Case Officer: Gemma Magnuson

Recommendation: Approve

Proposal: Loft conversion including insertion of two dormer windows in front elevation.

PROPOSED FRONT ELEVATION (SOUTH)
Scale 1:100 @ A1

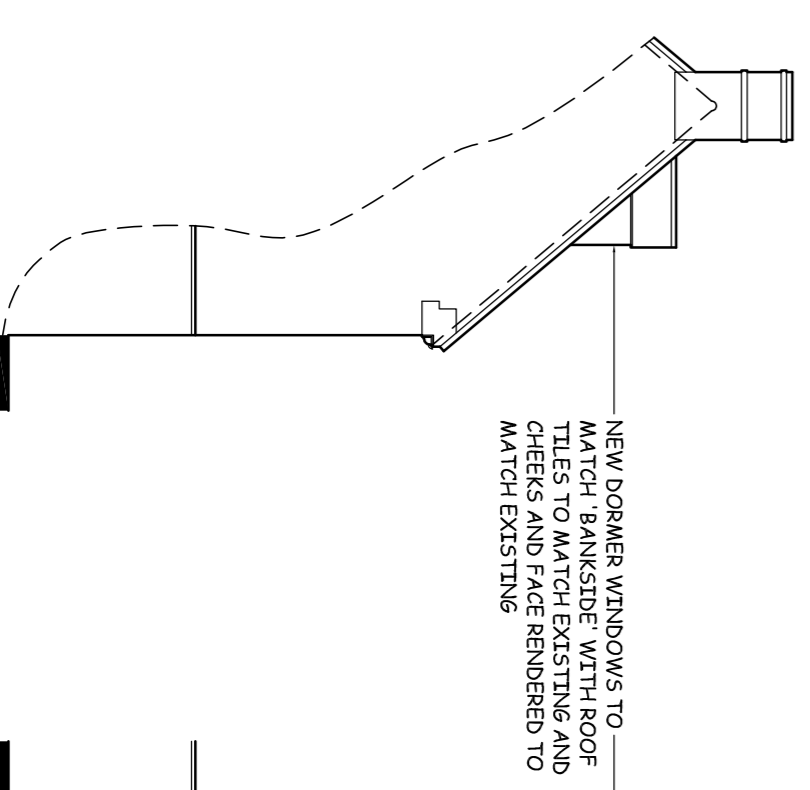
- 6.3. CDC Conservation – no objection subject to them matching those at Bankside, to be conditioned.
- 6.4. CDC Ecology – no objection subject to condition regarding timing of the works and the bird nesting season.

- 8.5. Holly Mount is one of a pair of semi-detached dwellings situated in a prominent location within the streetscene. The other dwelling, Bankside, has existing dormer windows within the front facing roof slope (see 03/00857/F) and the proposed dormers would match these. The dormers would be positioned in line with windows in the ground and first floors and would not appear top heavy. I consider that the works would result in a more a balanced frontage for this pair of dwellings, and I do not consider that harm would be caused to the historic significance of this non-designated heritage asset, the setting of nearby listed buildings of the designated Conservation Area.

- 8.6. The Conservation Officer appears to reach the same conclusion, bearing in mind what could be constructed here as permitted development, although further details of the dormer windows are requested via condition. I have not recommended a condition as the plans have stated that the dormer windows would match those at adjacent Bankside, with roof and cheeks to match those existing. I do not consider that I could add more to this through the assessment of details. I have recommended a condition requiring the dormer windows to match those at Bankside.

3. The proposed dormer windows shall match those upon the south facing roofslope at Bankside Cottage, the adjoining dwelling to the east of the site, in terms of design, material and colour/finish.
